DRB Application No.: 09DRB-70298 Project # 1007637
Project Name: CASAS SERENAS ADDITION
Agent: Alpha Professional Surveying Phone No.:

DRB Comments

RE: Lots 8 & 9, Block 6, Casas Serenas Addition

PLAT OF
 LOTS 8-A & 9-A, BLOCK 6
 CASAS SERENAS ADDITION
 in Section 30, T10N, R4E, NMPM
 City of Albuquerque
 Bernalillo County, New Mexico
 September 2009

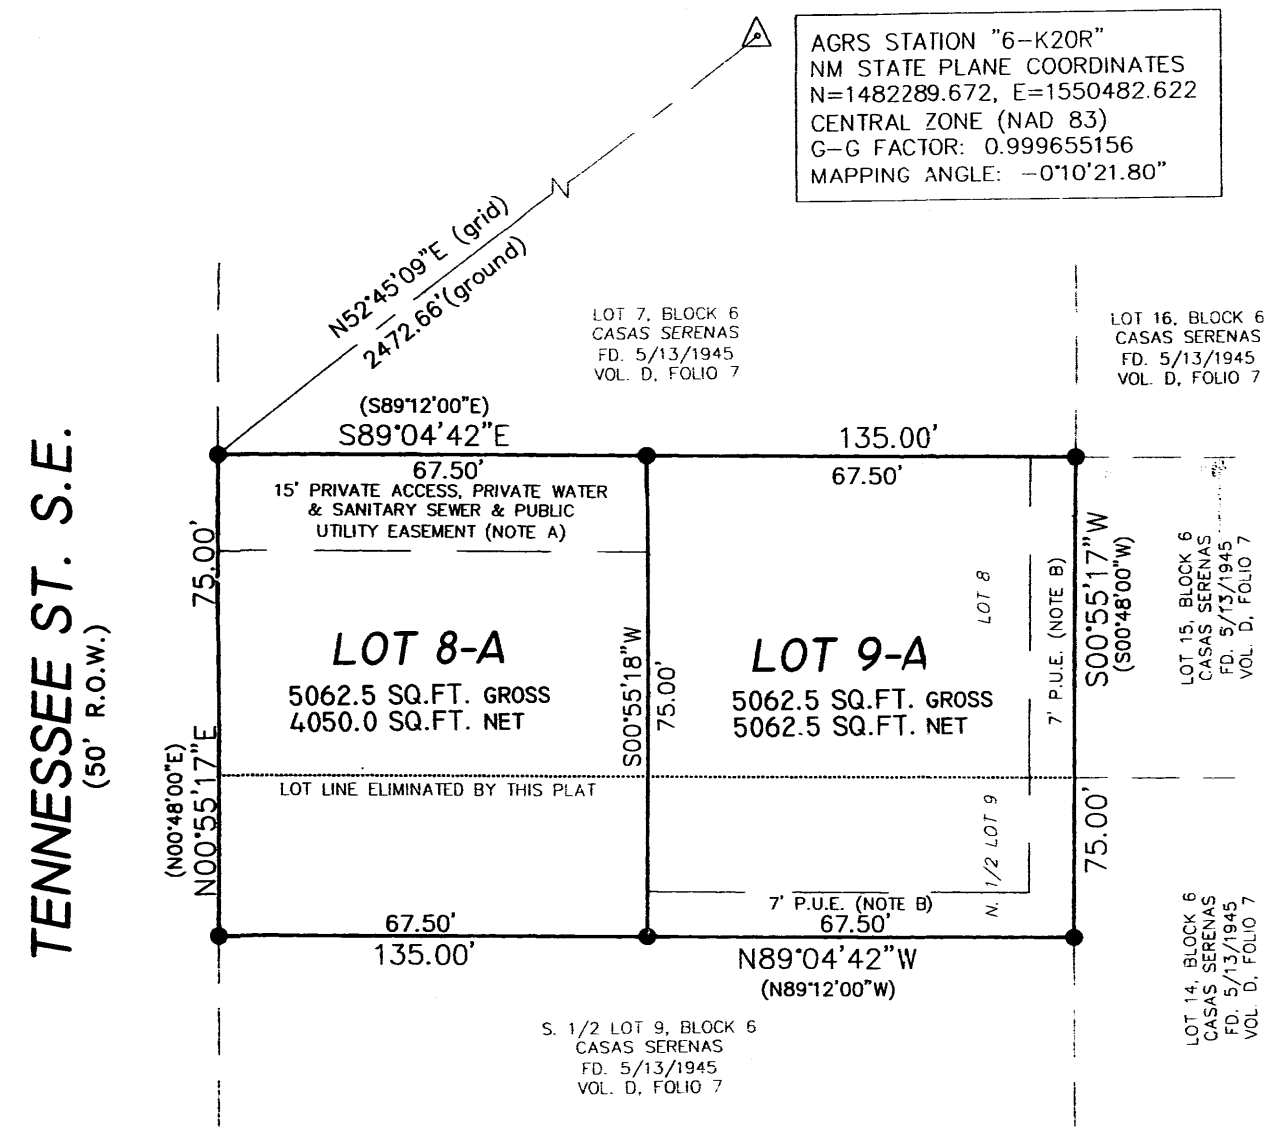
→ TRANSPORTATION: - clarify easement

The minimum access easement width for a single dwelling unit would be 15 feet, not 10 feet.
